PROPOSED IMMINGHAM EASTERN RO-RO TERMINAL

PINS REFERENCE TR030007

RESPONSE TO APPLICANT'S CHANGE REQUEST FROM DFDS SEAWAYS UK PLC

\\ukfsfp02.europe.jacobs.com\Maritime\PROJECTS\Ports\VT\B2429400 ABP Project Sugar\1100 Design & Engineering\1102 Drawings\01 Preliminary\02 DCO Drawings\B2429400-JAC-00-ZZ-DR-ZZ-0204 to 0206_P04.dwg - 19/10/2023 11:05:26 - 0206 - TALBOTDK

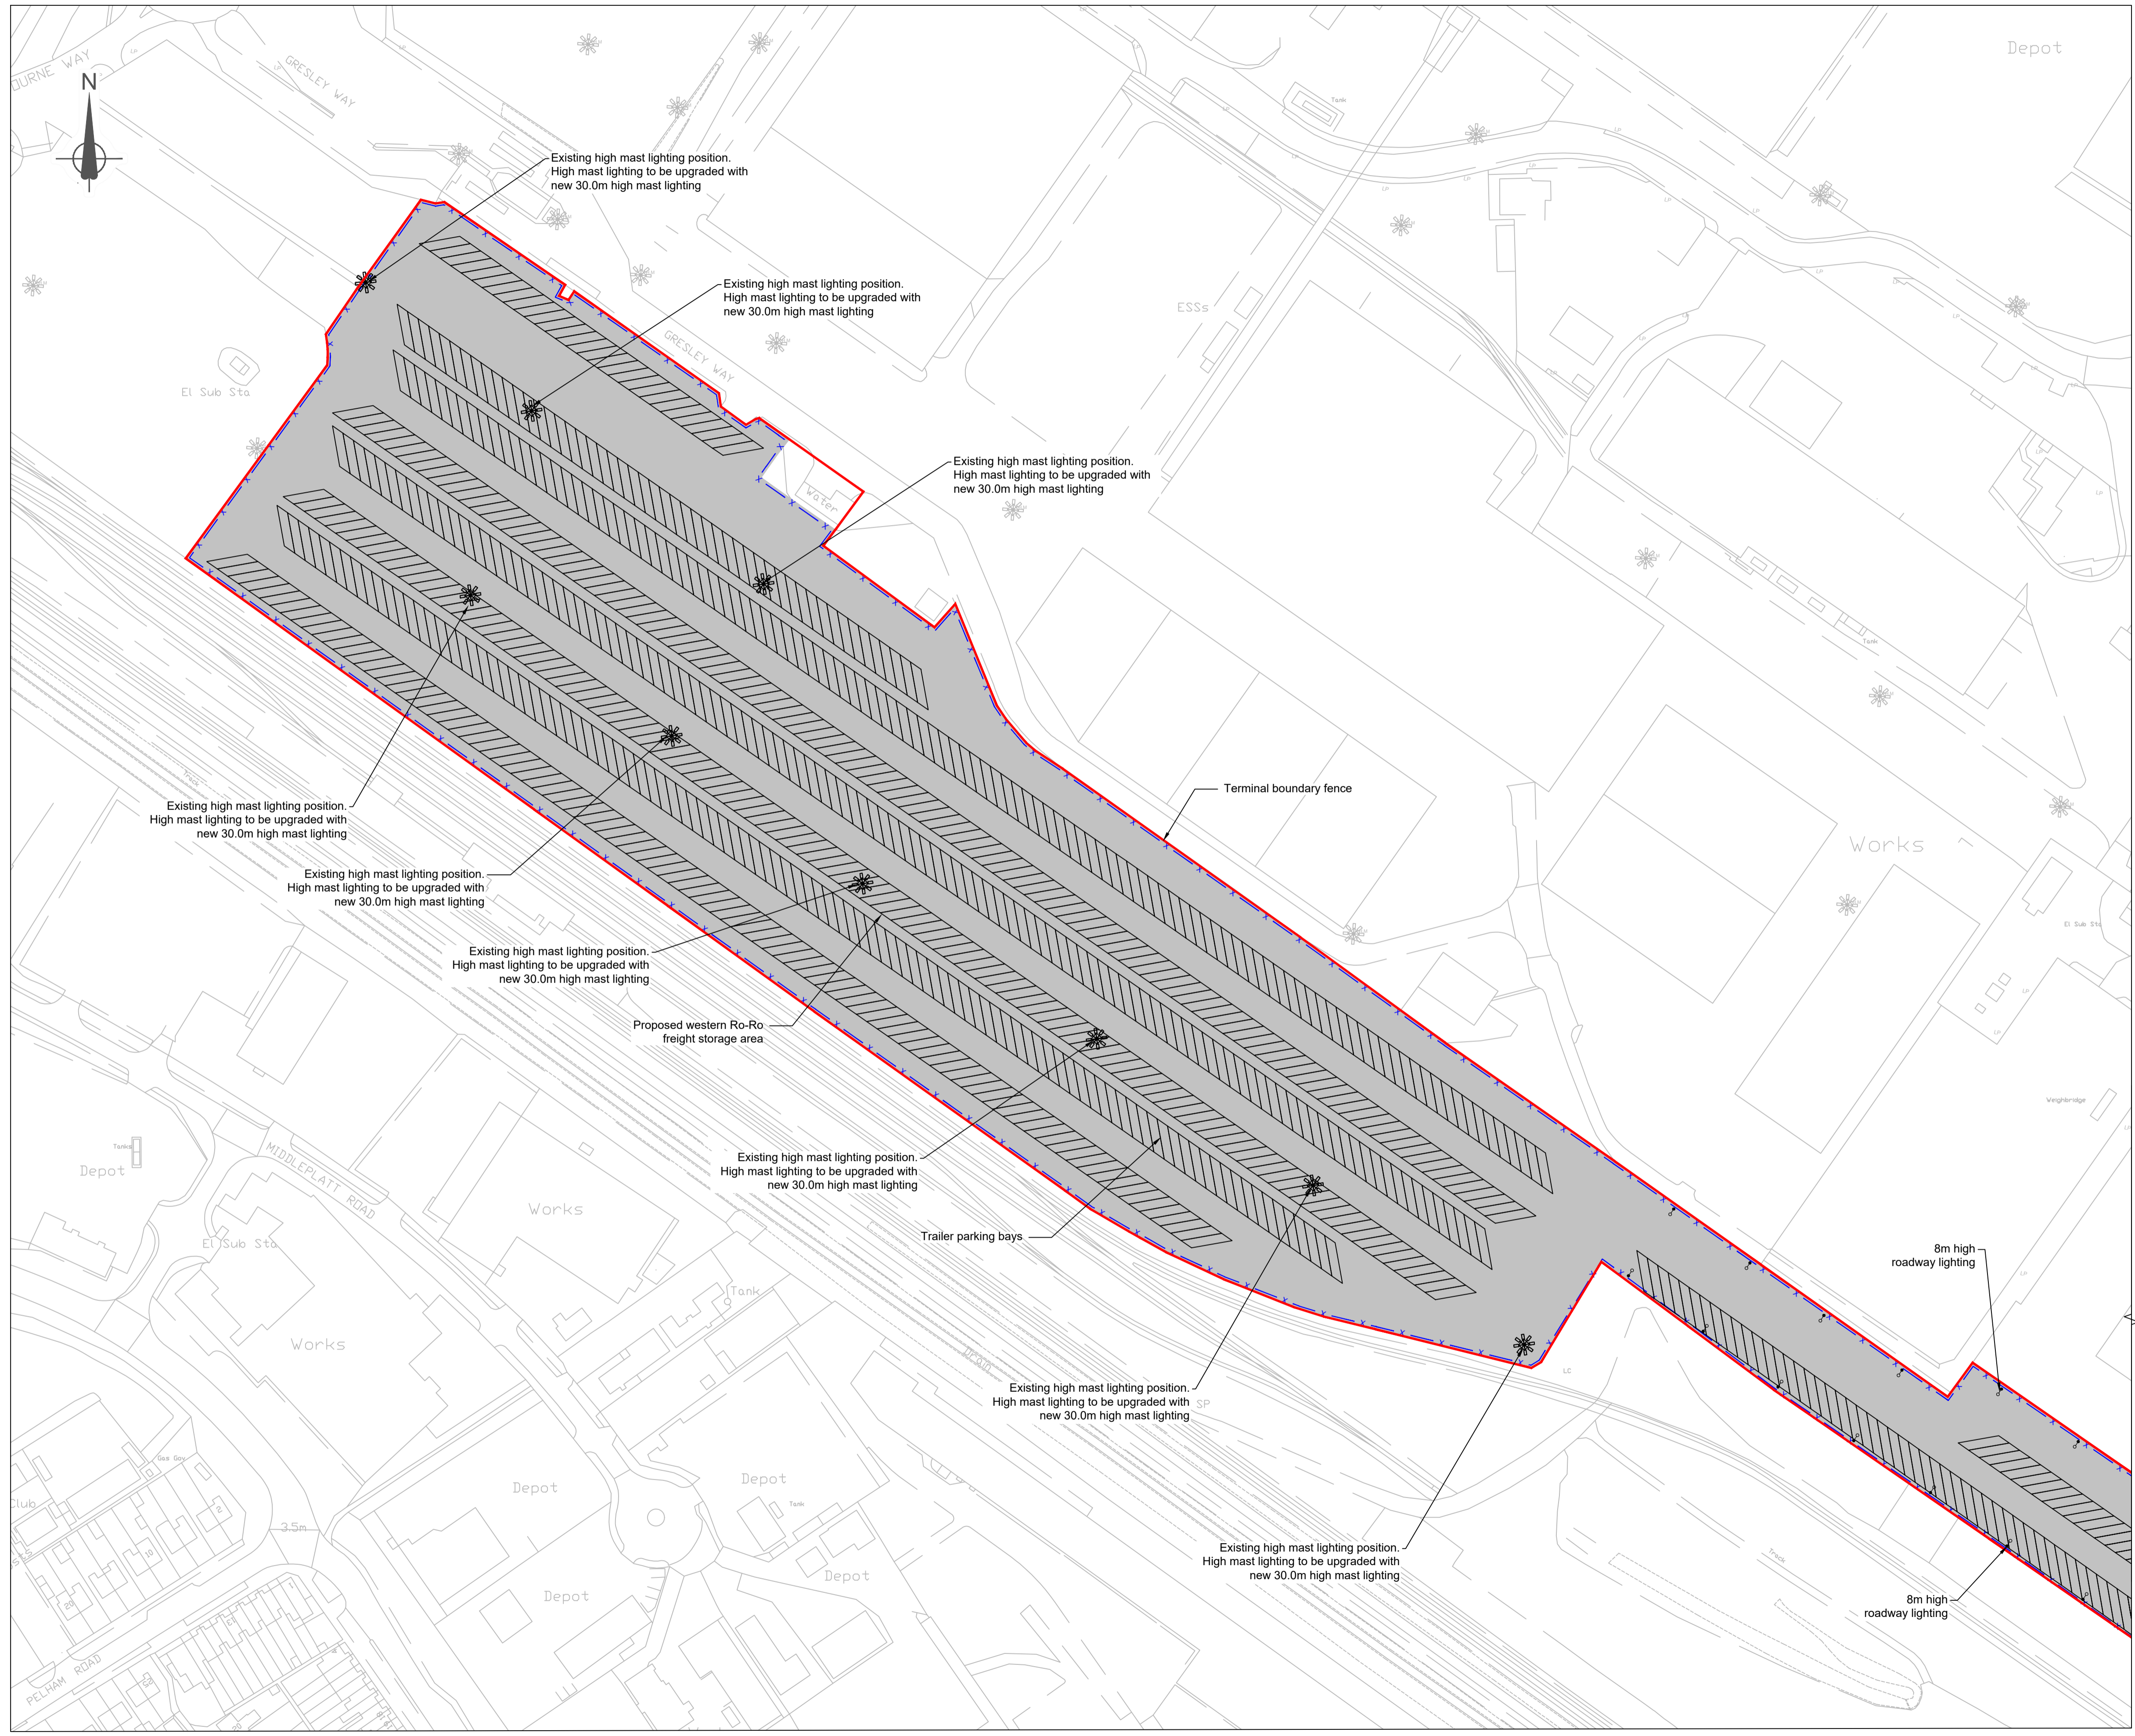
- 4.8 In the consultation version of the Environmental Statement Addendum it stated at paragraph 3.3.6 [AS-028] that there was to be a general increase in trailer spaces from 1,430 to 1,699. (3.3.6 of the ES Addendum) but no figure appears to be given in the 29 November version. The General Arrangement Plans [AS-029] and [AS-049] show the bays appear identical so presumably the total of 1,699 still stands.
